Kitchen Plumbing Clarifications

TO:	Miranda Jones (WBRC Architects and Engineers) 44 Central Street Bangor, Maine 04401	FROM:	Jason Goggin (Consigli Construction Co., Inc.) 15 Franklin Street Portland, Maine 04101
DATE INITIATED:	07/22/ 2016	STATUS:	Open
LOCATION:		DUE DATE:	07/26/2016
COST CODE:		REFERENCE:	
COST IMPACT:	TBD	SCHEDULE IMPACT:	TBD
DRAWING NUMBER:	PL102, PL401, FS001, PL101	SPEC SECTION:	
RECEIVED FROM:	Mike Lowe (Damon Refrigeration Co, Inc.)

Responses per numbered items in RFI #23

PROJECT MANAGER: JRB SHEET No. **PL101**

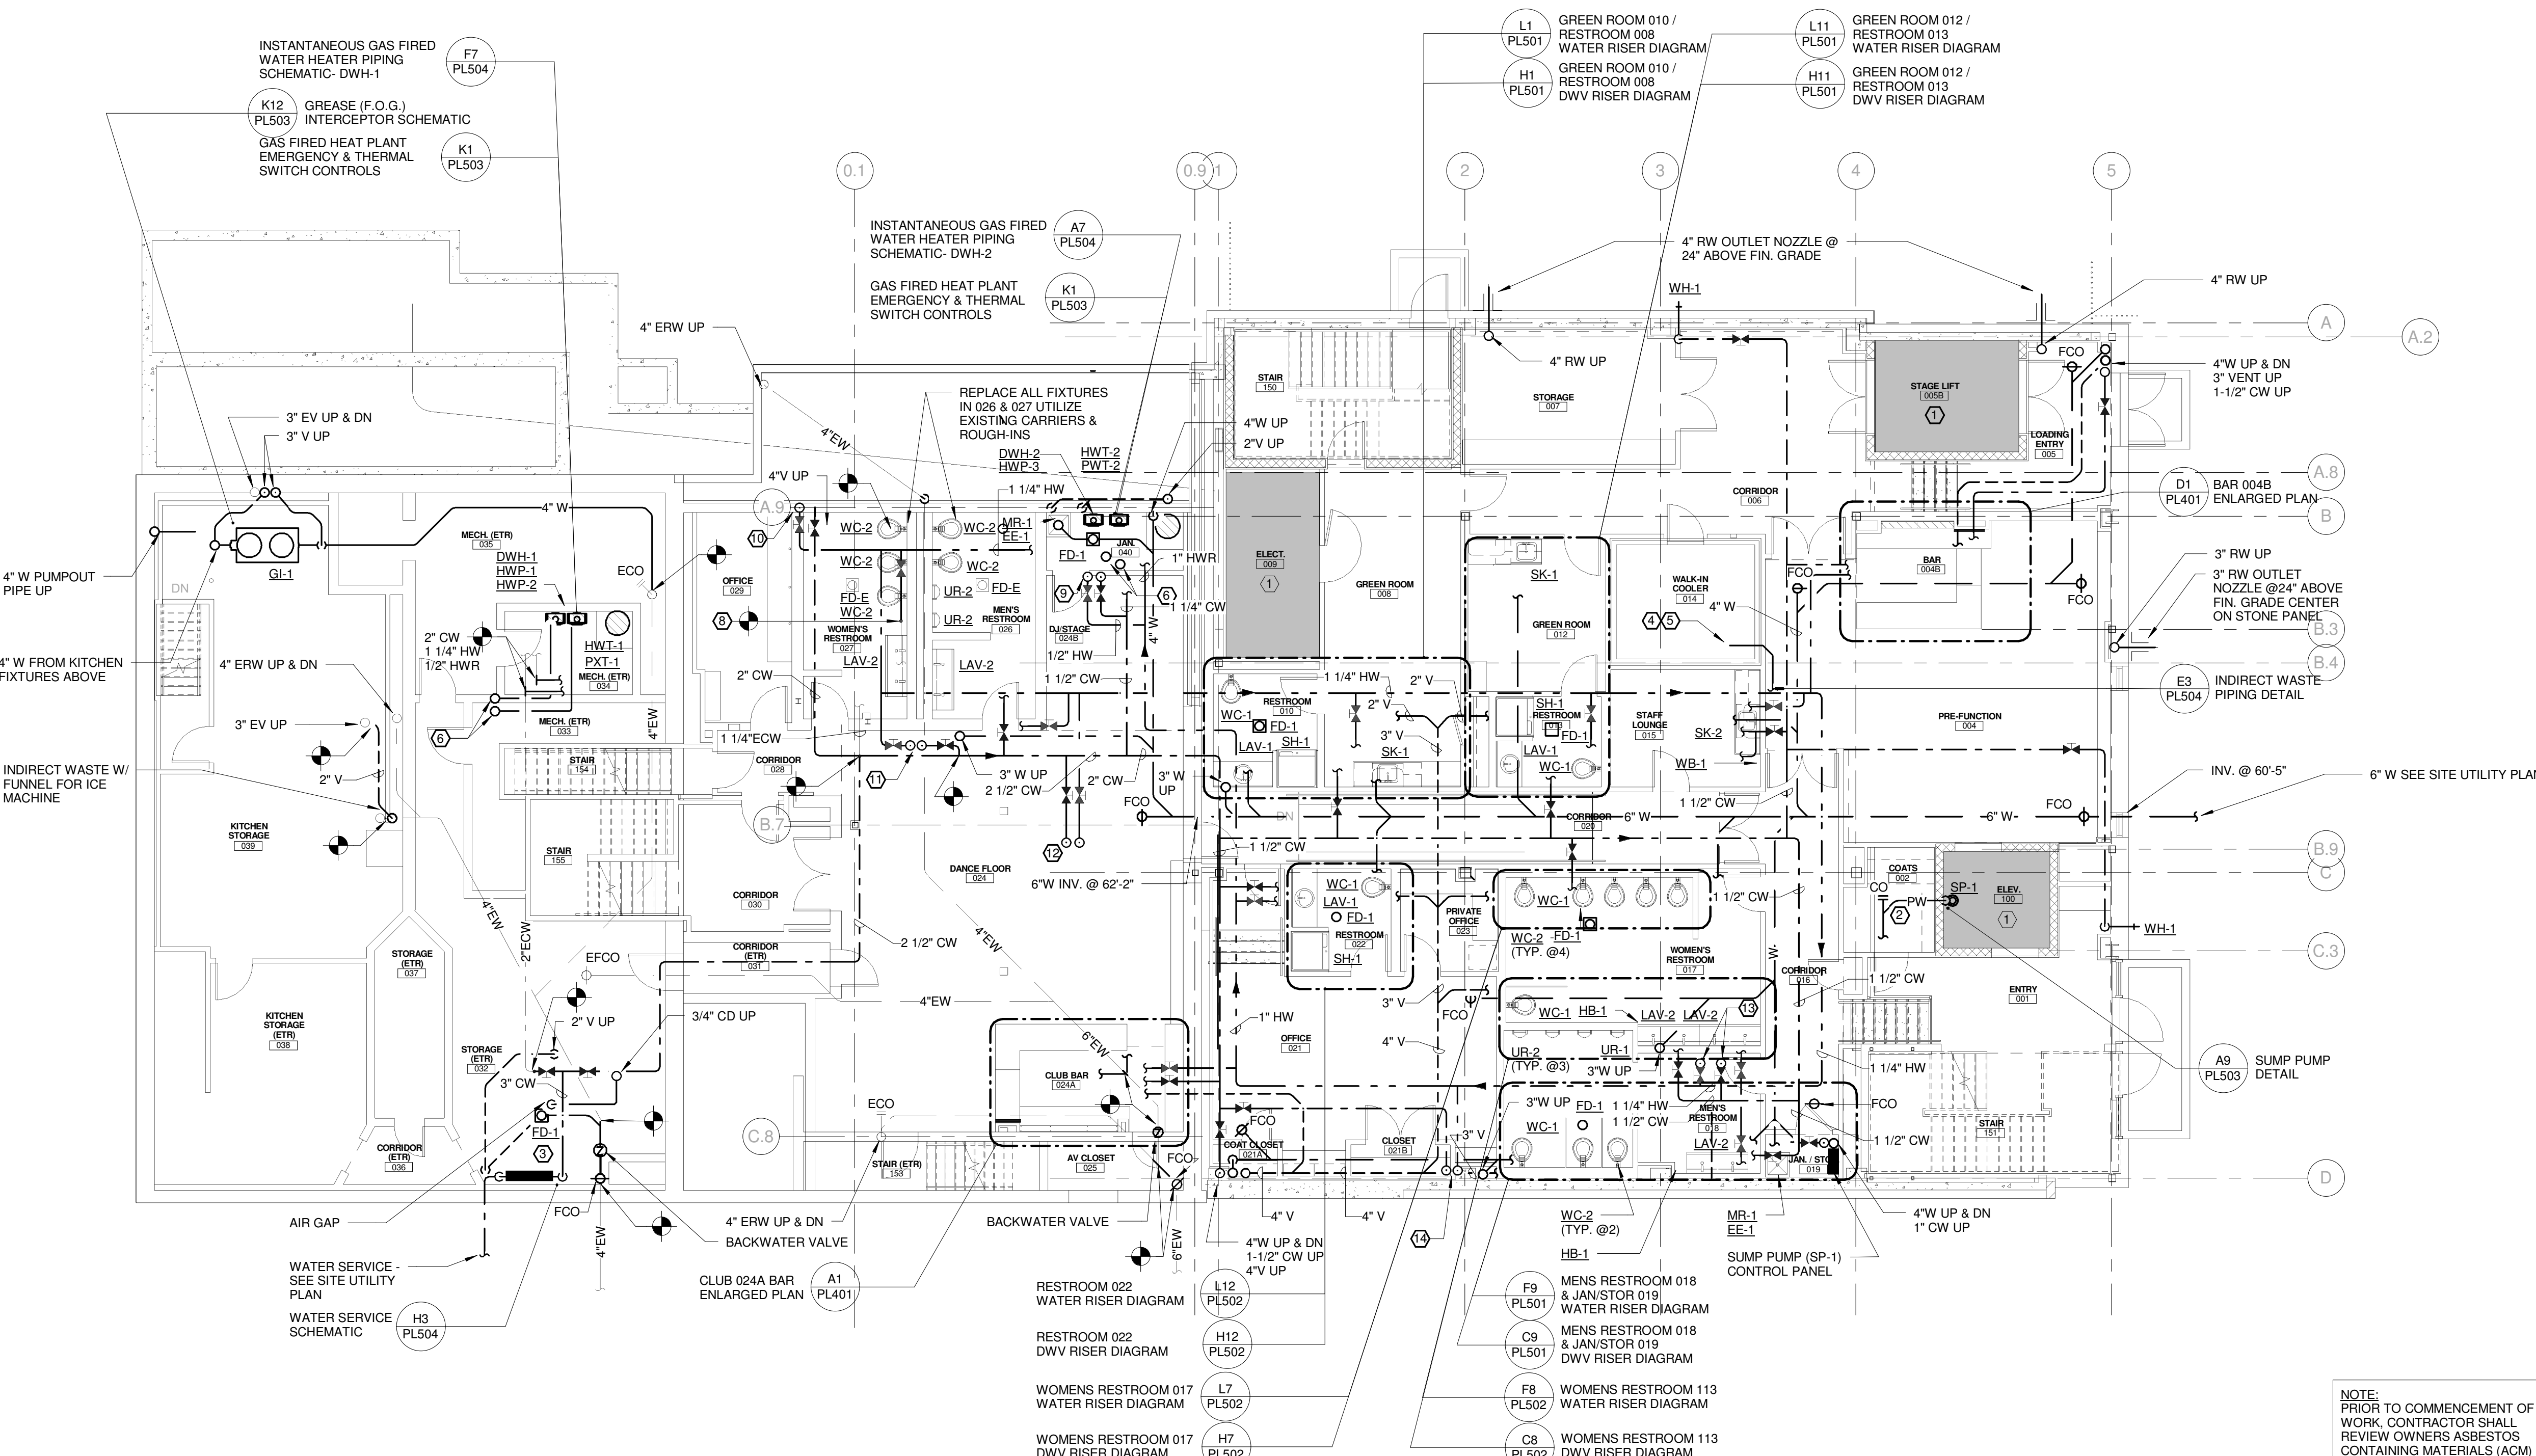
6. Per PL101 there is to be a new hot water tank in janitor's closet 040. Note there is an existing wet sump hole with perimeter drainage piping coming in and a sanitary drain with trap to serve this area drain. The drawings do not appear to indicate anything in this area. Please provide an alternate location for this hot water tank. Note that rework of the existing area drain and/or the relocation of this hot water tank may have added costs.

6. Proposed alternate location for hot water tank tagged HWT-2 in Jan 040 is to flip hand of layout of wall mounted water heater DWH-2 and the tank. Locate HWT-2 beside the mop sink and locate the wall mounted water heater above existing sump. Maintain the existing sump and provide cover.

PROJECT MANAGER: JRB SHEET No. PL102

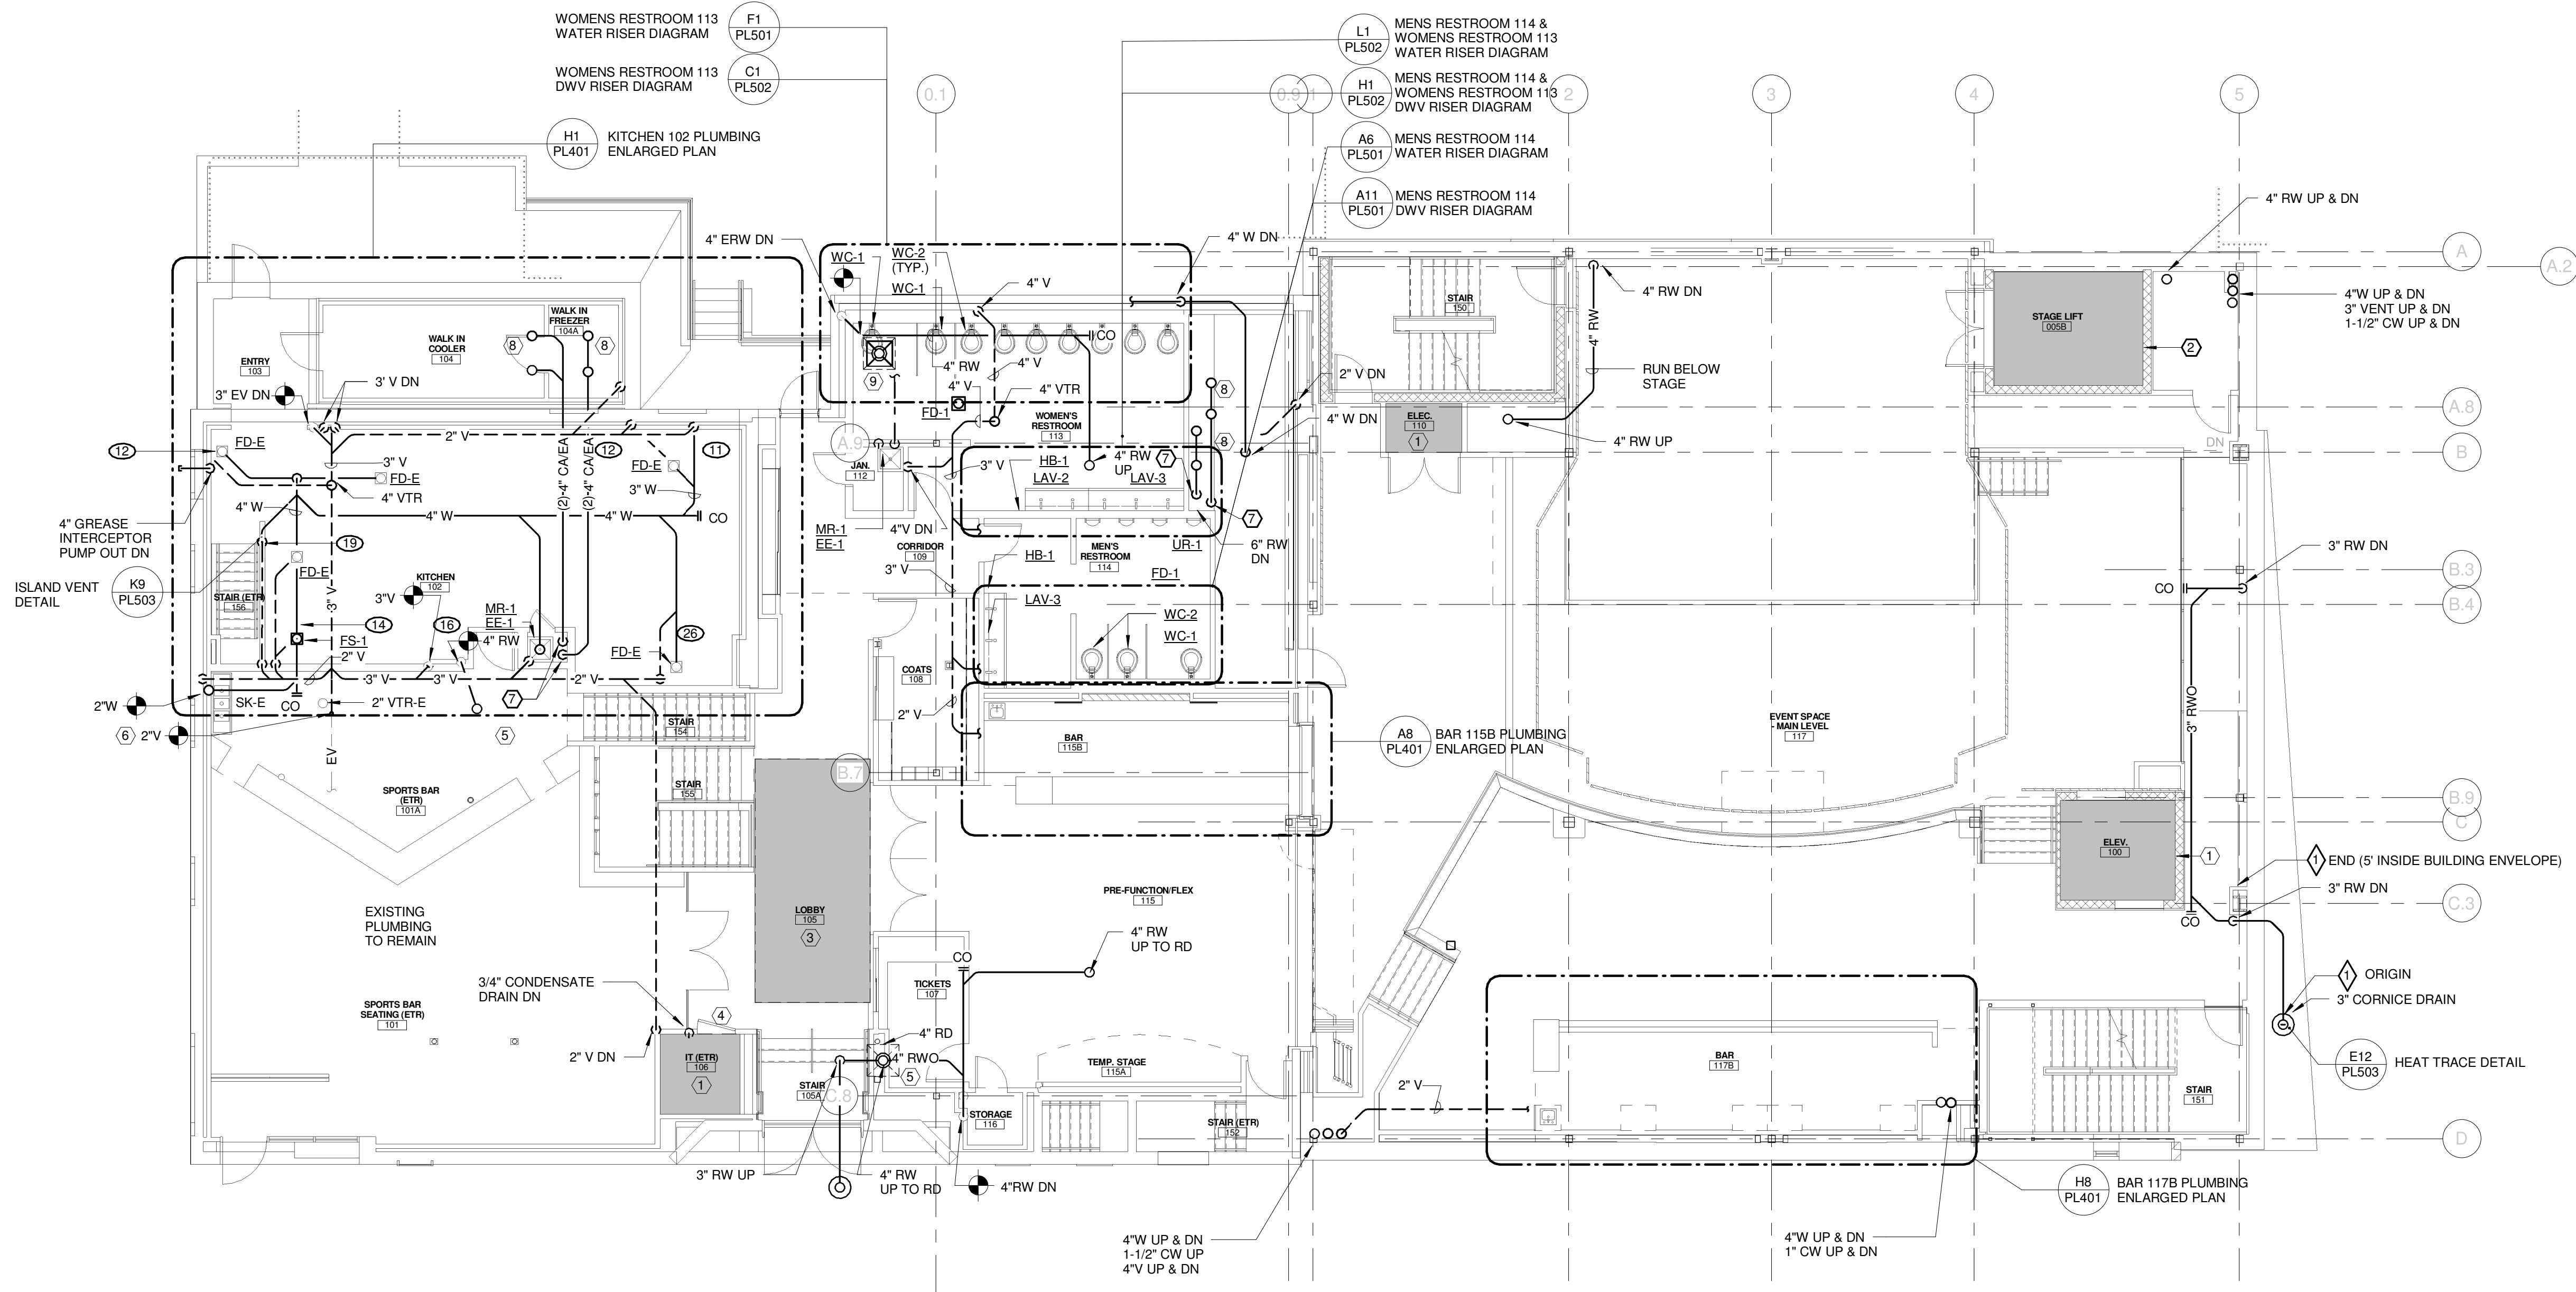
1. Per PL102 there is an eyewash station EE-1 shown in the mop sink closets, kitchen closet 102A and janitor's closet 112. Please provide mounting locations for these fixtures.

2. Per PL102 and PL401 there is new vent piping serving each new trap arm for the new kitchen equipment and existing floor drains. Note that the North wall currently consists of strapping and GWB on brick. Per AE102A this wall is shown as existing to remain which will not allow for these pipes to be concealed within the walls. Please advise if this wall should be furred out to allow for the new plumbing or if this piping. Note that this has added cost to frame and hang this new wall.

4. Per PL102 there is to be new waste and vent piping to serve all existing floor drains. As currently shown these appear to tie into the new grease trap. Additionally, the garbage disposer is shown discharging into one of these floor drains. Per Maine State Plumbing code (2009 UPC Chapter 10 1001.3 and 1014.13) this device must be directly connected to its own trap and may not be discharged into a grease waste receptor. We recommend running a separate main to serve this disposer and tie it into the outlet piping of the grease interceptor. Note that this work would have added costs associated with the new main. Please advise how to proceed.

5. As currently shown on PL102 it appears that the commercial dishwasher is draining into the floor drain under it. Per current plumbing code (2009 UPC Chapter 7 704.3) this equipment should be directly connect to the sanitary system. We recommend installing a new sanitary rough in with vent piping to serve this existing dishwasher. Note that this added sanitary and vent piping would have additional cost. Please advise how to proceed.

1. Intent is for wall mounting of eyewashes with top of spray heads 48" above finish floor and adjacent to, but not directly above the mop sinks. Coordinate exact location with mop sink accessories and other wall mounted devices to maintain access.

2. Intent is to conceal vent piping. Coordinate with RFI #11 response regarding kitchen walls.
3. Remove FD-E. Provide a new floor sink type FS-1 in location as indicated in the referenced kitchen equipment drawing. Coordinate with RFI #16 response regarding the kitchen floor.

4. Based on coordination and review during design with the City of Portland Department of Public Works Frank Brancely the garbage disposal is to be removed. (Refer to Addendum 2 item 30 for coordination with Department of Public works for coordination for required inspections).

5. Based on coordination and review during design with the City of Portland Department of Public Works Frank Brancely the dishwasher is to be connected to the grease trap. Provide direct connection. (Refer to Addendum 2 item 30 for coordination with Department of Public works for coordination for required inspections).
